**KIRKLEES METROPOLITAN COUNCIL
INVESTMENT & REGENERATION SERVICE**

DELEGATED DECISION TO DETERMINE PLANNING APPLICATIONS

Reference No:	2025/62/93530/W
Site Address:	Highfield, Green Cliff, Honley, Holmfirth, HD9 6JN
Description:	Erection of first floor and front extensions (within a Conservation Area)
Recommending Officer:	John Holmes

Officer Report – 2025/93530

Drawing No.	Rev No.
MJO001 -003

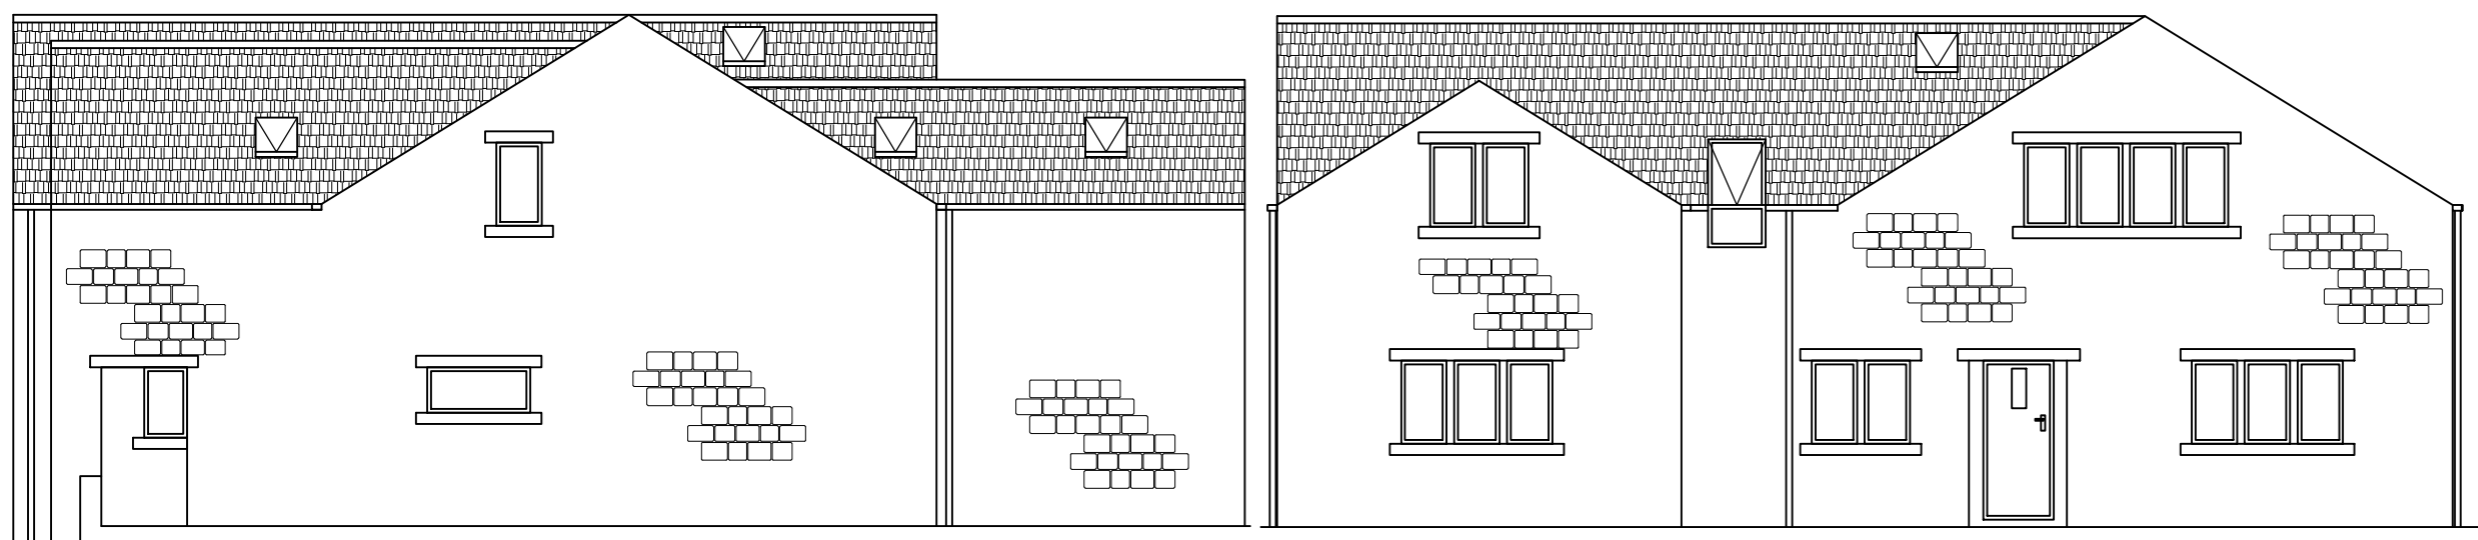
- Eaves height of 7m and ridge height of 9.4m when measured from the front (currently 5.1 and 7.5).
- Extension above an existing terraced area, which would be set slightly behind the frontmost part of the building (by 0.5m).
- Raising rear eaves to 4.3m and 6.7m (currently 2.6m / 5.1m)
- Rear elevation – Addition of first floor windows and roof lights
- South western (side) elevation – addition of 2 windows and roof lights to roof slope
- North eastern (side) elevation – addition of first floor window and roof lights
- Front elevation – addition of first floor and second floor windows with the first floor openings being full height openings.

The proposal would not be in strict accordance with the SPD in relation to front extensions, although it is considered sufficient justification is present in this case in that the proposal is to an individually designed house type and would not protrude beyond the frontmost part of the existing front elevation.

The proposal would lead to an increase in the bulk and massing which is along the shared boundary with the property to the south west of the site. However, this is mitigated to some extent by the fact the eaves would be at this shared boundary and slope away from the element of the scheme which comes forward of the property to the south west. The additional scale and massing are not considered to be significantly greater than that of extant consent 2024/93548 and it is concluded that on balance the impact in terms of overshadowing / oppressiveness would not be so significant that refusal on such grounds could be substantiated.

The openings, including additional openings at first floor levels are not considered to lead to a significant level of overshadowing given they would be 21m+ for properties to the north east and opposite the front / rear. Given the extent of openings proposed to the south western (side) elevation, the proposal is considered to be acceptable in this regard.

3. Notwithstanding the plans submitted the external walls and roofing materials and all new windows and doors of the development hereby approved shall in all respects match those used in the construction of the existing building and be retained thereafter.

4. Notwithstanding the approved plans, the proposed roof lights shall be low profiled conservation style. The roof lights shall thereafter be retained with this finish.
